The Coal
Authority

Re: 2024/62/92727/E

Erection of residential development 67 dwellings with associated access, parking, public open space, landscaping and infrastructure; LAND ADJACENT TO, ASHBOURNE DRIVE, LIVERSEDGE

The Coal Authority response: **Additional Information required - updated layout plan to show how the on-site mine entries relate to the proposed layout)**

DRAWING TITLE  
**MINING FEATURES & PROPOSED CLIENT LAYOUT**

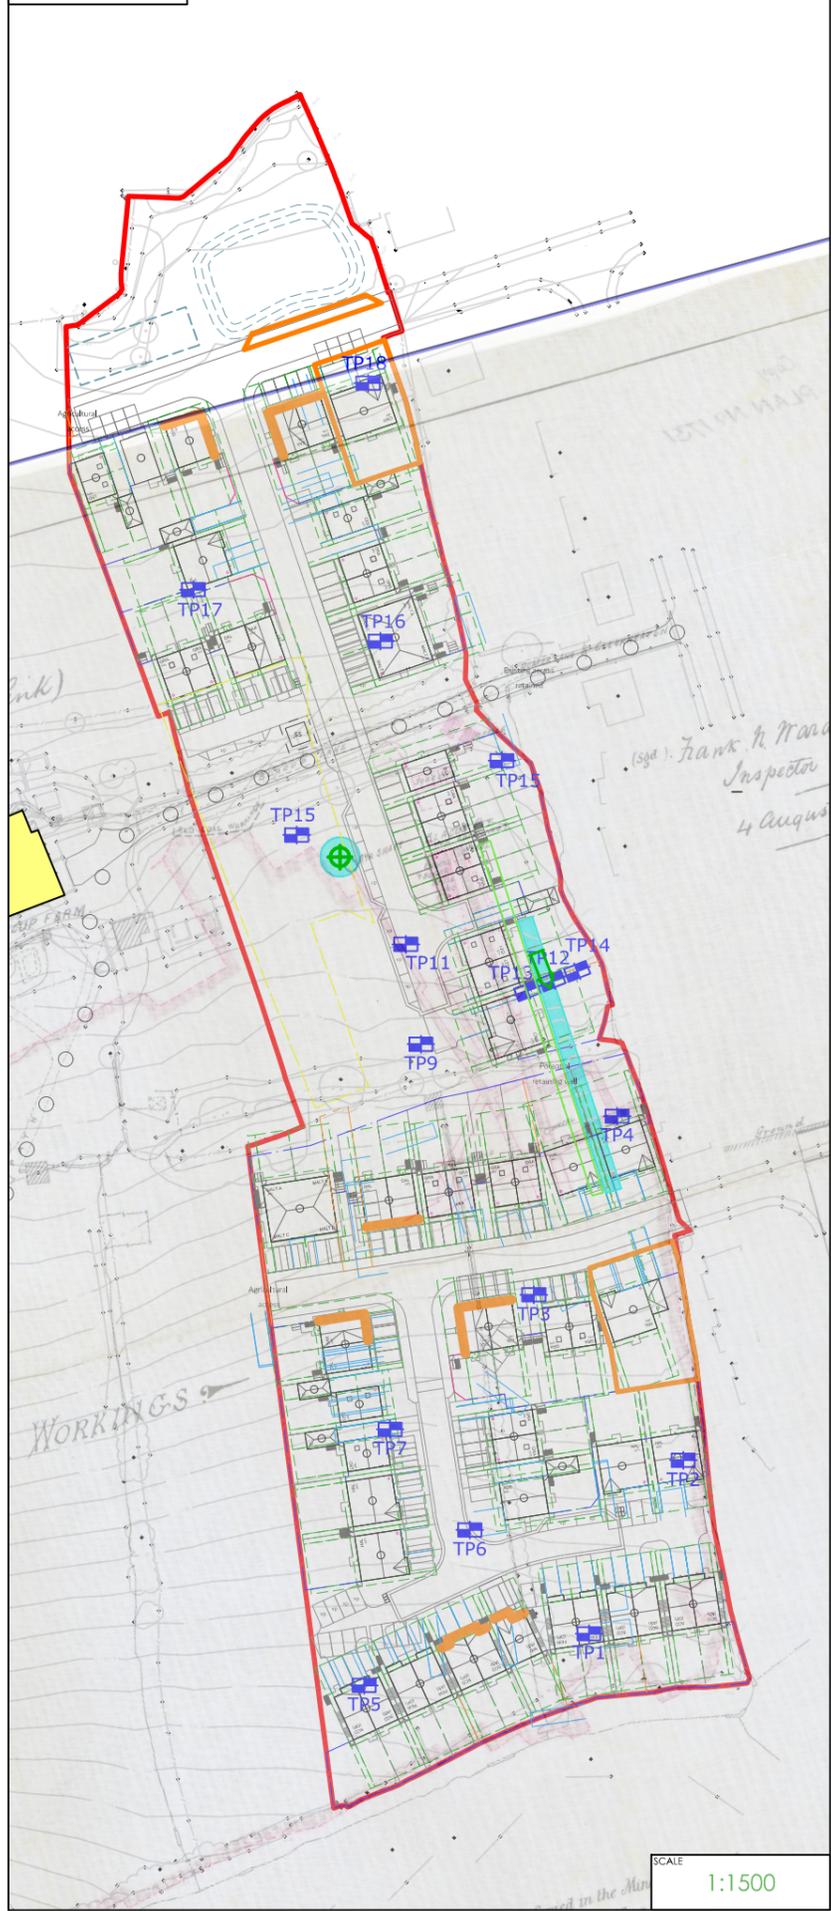
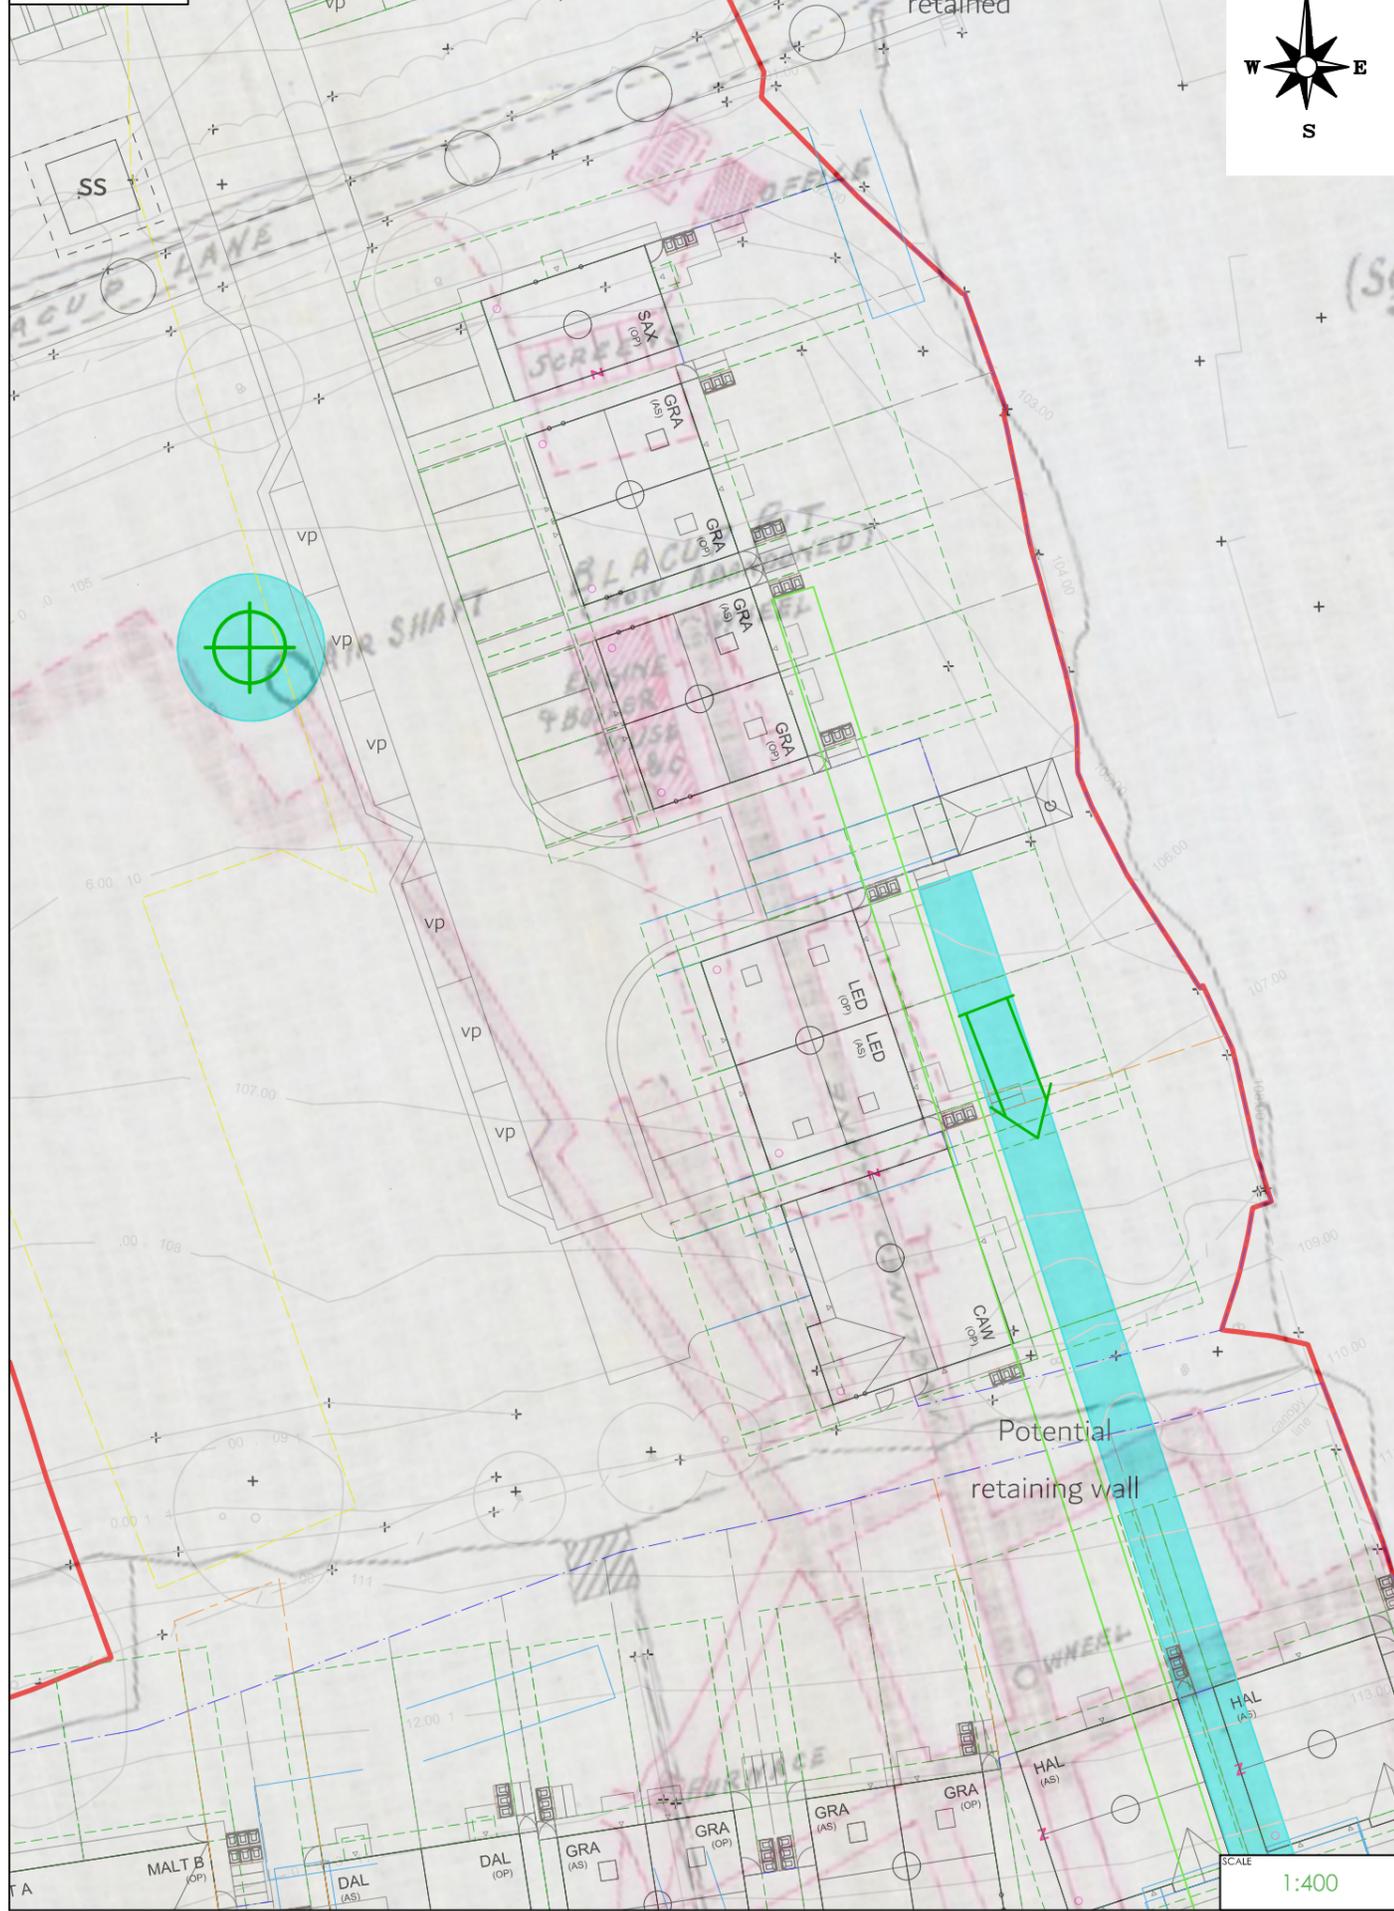
We are pleased to note that the location of the mine entries (and grid co-ordinates) have been illustrated on Drawing No. 1462/8a – Shaft & Adit Investigation with Photographs and recommendations have been made (Section 13.2.11) that any proposed development layout takes account of the location of the shaft and adit. It would appear that the mineshaft lies within the area of public open space; however, it is unclear how the mine adit and shallow roadway from this feature relates to the development.

We acknowledge that current authoritative UK guidance (CIRIA C758D – Abandoned mine workings manual), identify that shafts and adits present different levels of risk to a development and therefore require different levels of remediation works. However, we would expect these features and any zones of influence (no build exclusion zones) to be considered further. We consider it prudent that the on-site mine entries and any shallow roadway from the adit are clearly illustrated on the proposed site layout plans, including the calculated zone of influence (no build exclusion zone) of these features. This will provide a clear representation of how these features relates to the overall development and to demonstrate the applicant has afforded due consideration to the recommendations made by their geotechnical consultant (Lithos Consulting Limited) as per Section 13.2.11.

Drawing No. Z168.002 Rev. E

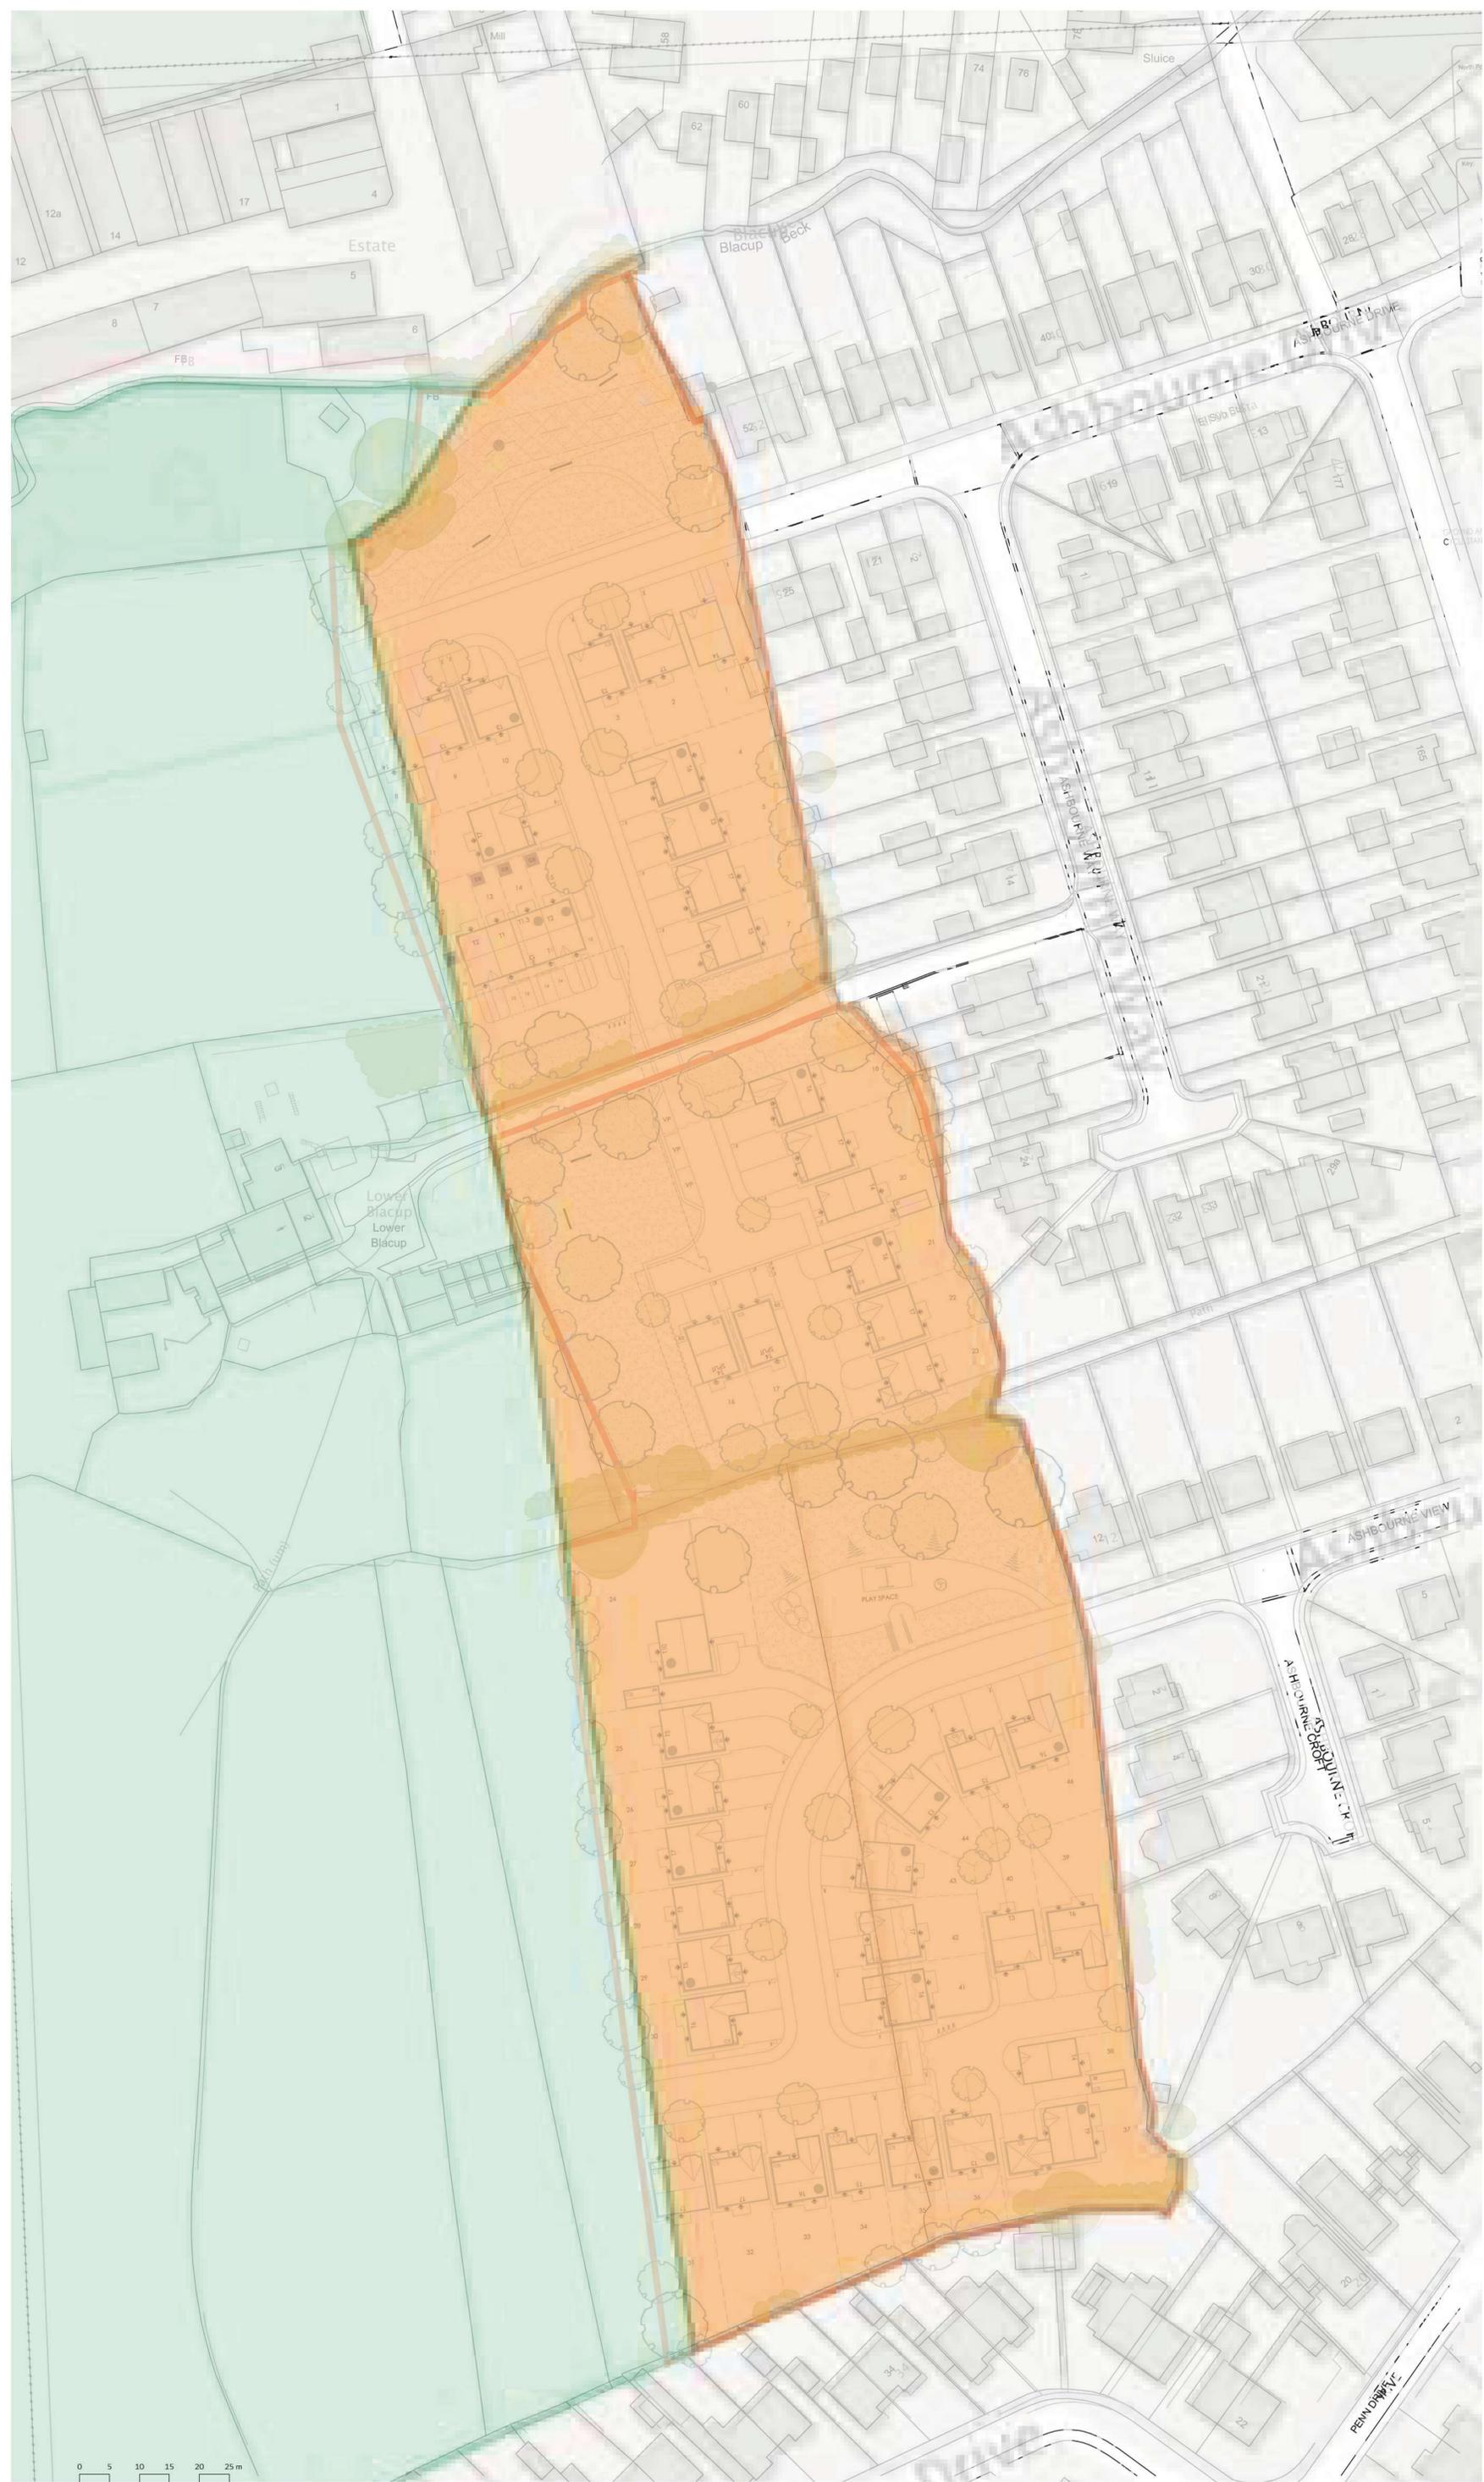
I have reviewed the proposals and confirm that parts of the application site lie within the Development High Risk Area as defined by the Coal Authority. In accordance with Drawing No. Z168.002 Revision E (Planning Layout) it is only Plots 1 – 4 and 11 – 14 that lie outside the Development High Risk Area. Therefore, within the majority of the application site and surrounding area there are recorded coal mining features present at surface or shallow depths. The risk these features may pose should be considered as part of the planning process.
